**Re: MHP/AOC Respite Care Addition, 715 Candelaria Rd.NE,
Traffic Circulation Layout
Architect's Stamp Not Dated (G15—D001)**

Based upon the information provided in your submittal received 01-29-13, the above referenced plan cannot be approved for Building Permit until the following comments are addressed:

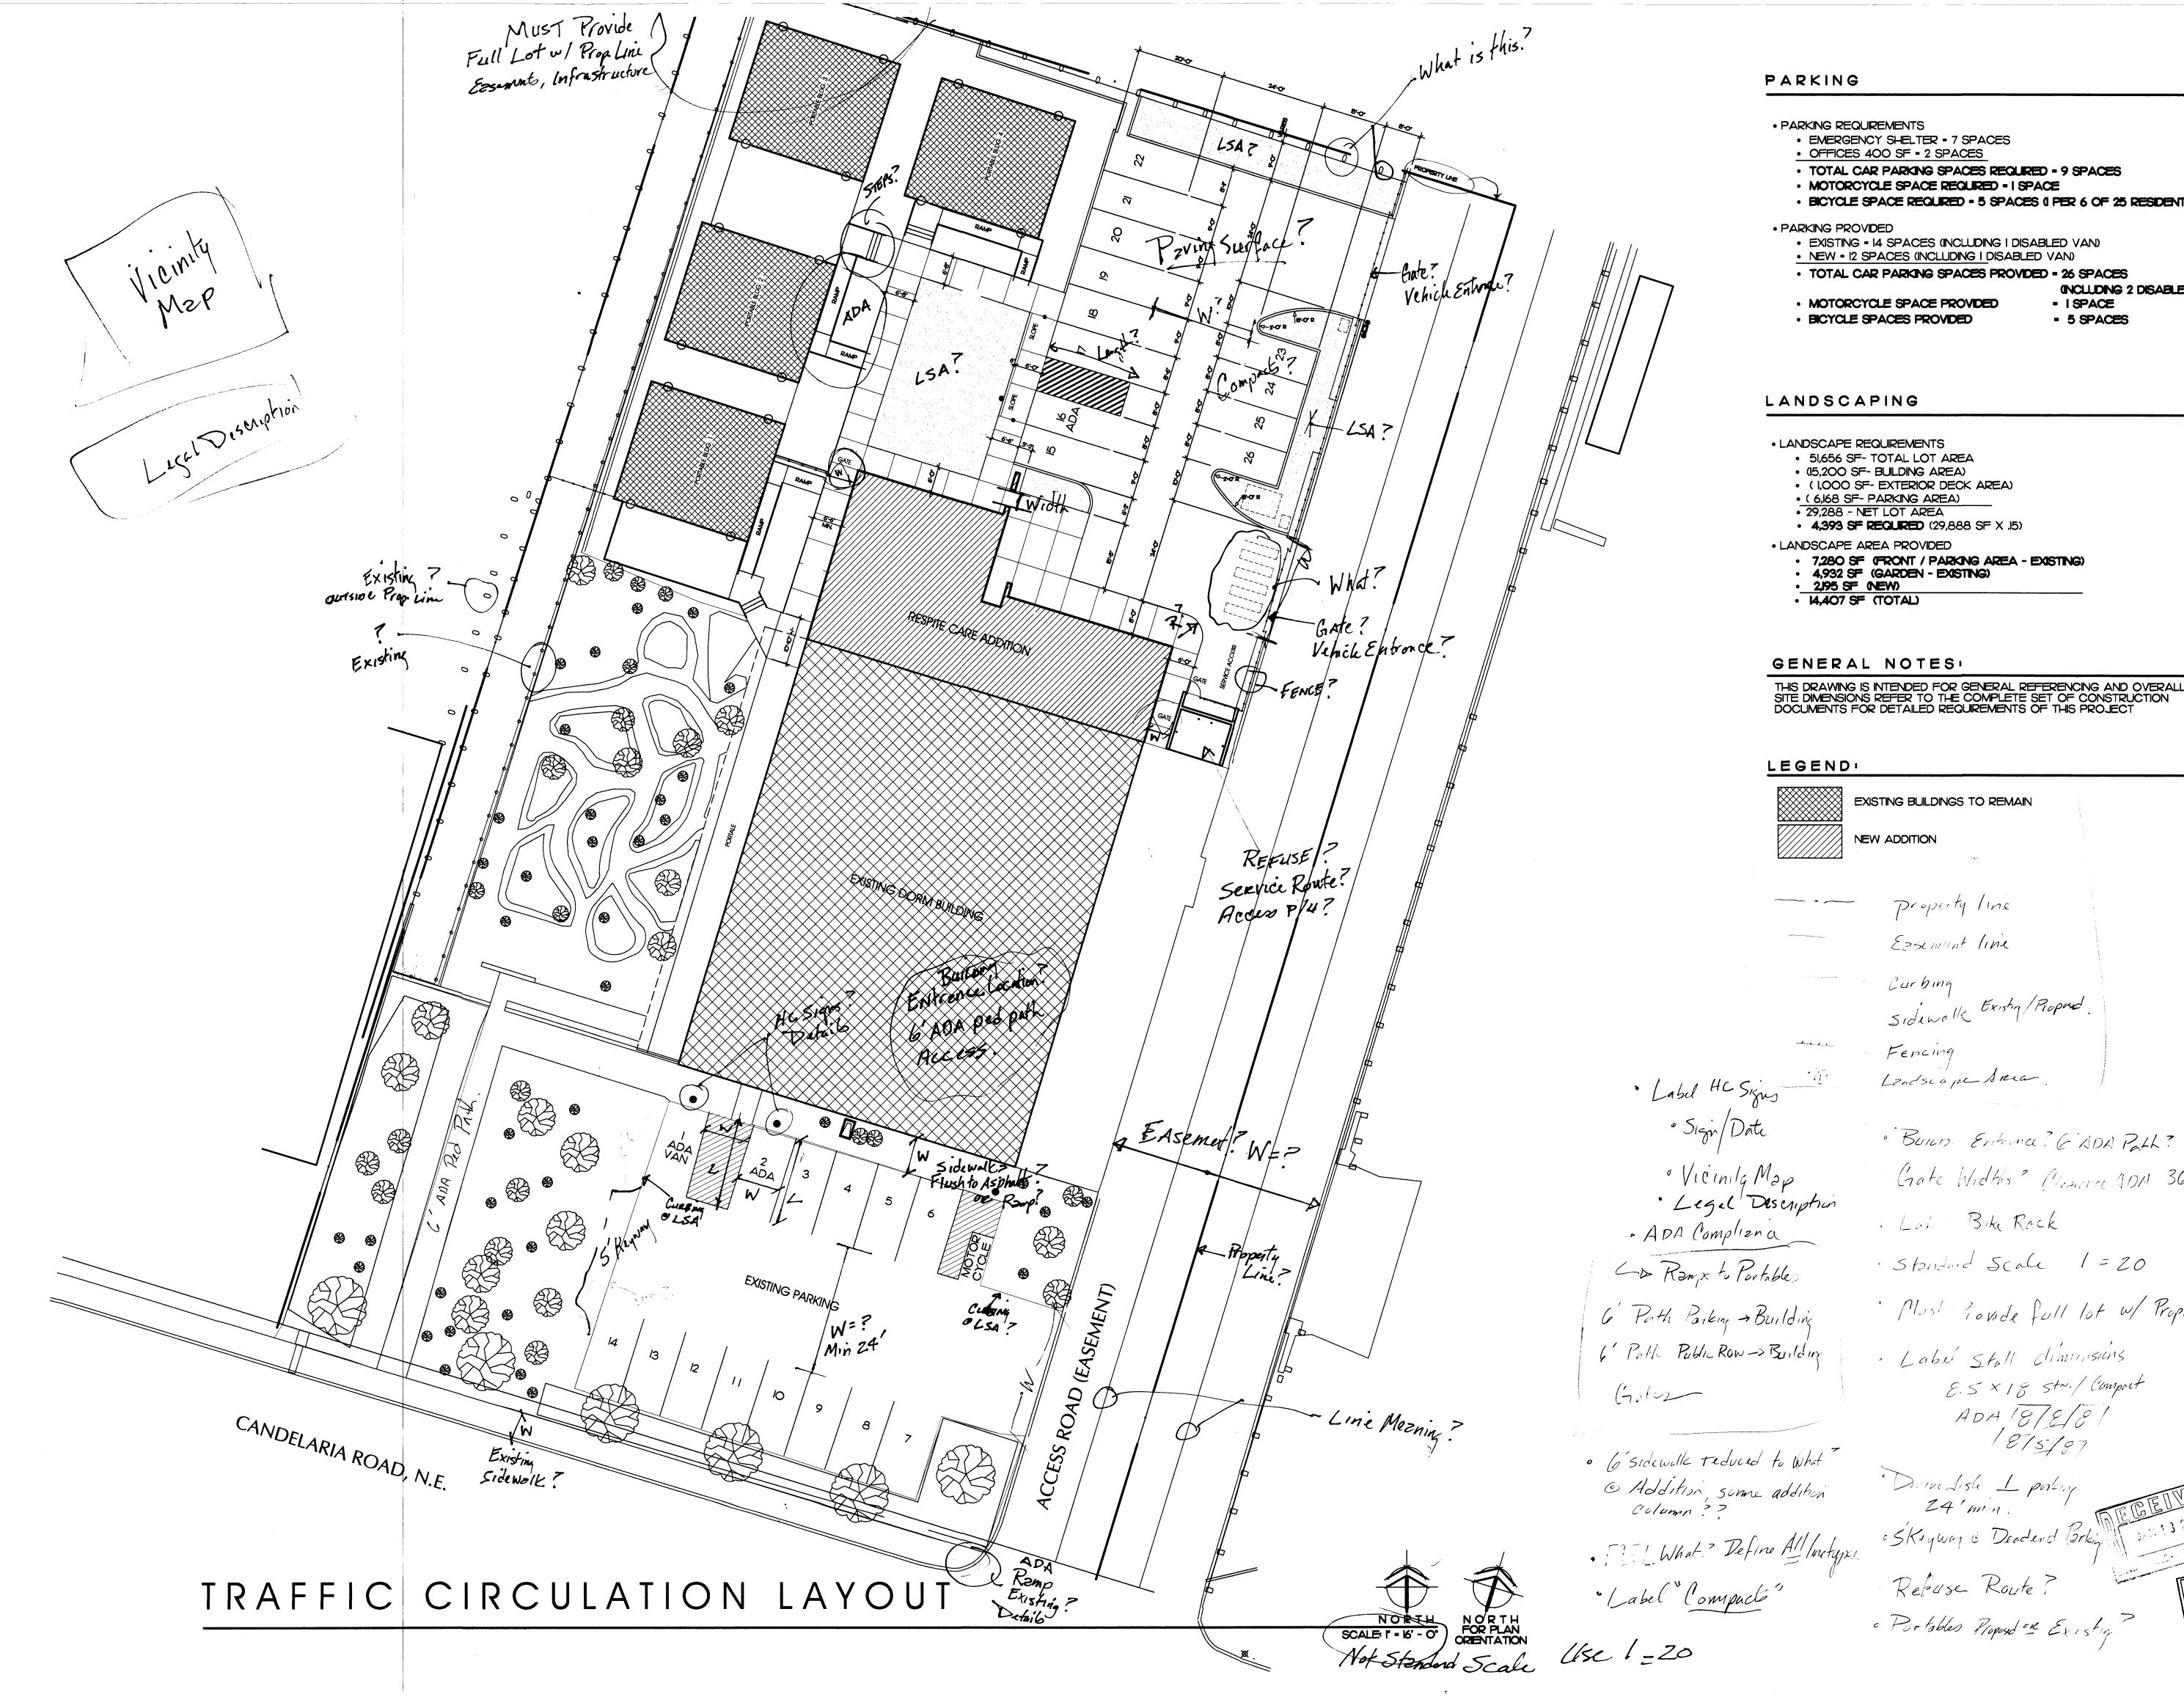
1. Please ensure all ramps are ADA compliant.
2. Please provide a six foot, concrete, ADA accessible, pedestrian walkways from street sidewalk to the principal customer entrance of the nearest building on site.*

3. The concrete landing abutting customer entrance does not appear to be ADA compliant. Please refer to current *2010 ADA Standards for Accessible Design*, Ch. 4, section 404, for maneuvering clearances at manual swinging doors.

4. The vehicular pavement markings for the parking lot circulation show one-way circulation. One-way parking and circulation have specific *Development Process Manual (DPM)* requirements, angled parking stalls and narrow drive aisle widths, to ensure intended circulation movement. The proposed perpendicular parking stall layout with 24 foot drive aisle conforms to a two-way layout. Please design parking lot to conform to DPM standards Chapter 23, figure 23.7.1.

5. Please provide details for the proposed security fence and gates adjacent to the drive aisles at the proposed parking area. Refer to *DPM* Chapter 23; section 6.12 "*Visibility for Driveways.*" Please demonstrate that the minimum 11 foot clear sight triangle is maintained between the vertical heights of 3 to 8 feet.

*The TCL site plan references an “Existing 6’ ADA Pedestrian Path” connecting the public ROW fronting Candelaria to the buildings entrance. The crusher fine path does not qualify as ADA accessible in this situation because it is located in an urban area, with the high traffic volume potential and the path can not ensure a “firm, stable, and slip resistance surface” during and following inclement weather. According to the *IEBC*, section #605.1, the building addition proposed will require the existing site to comply with current ADA standards. The exception would be to provide proof that the cost to comply would be greater than 20 percent of the entire cost of the addition.
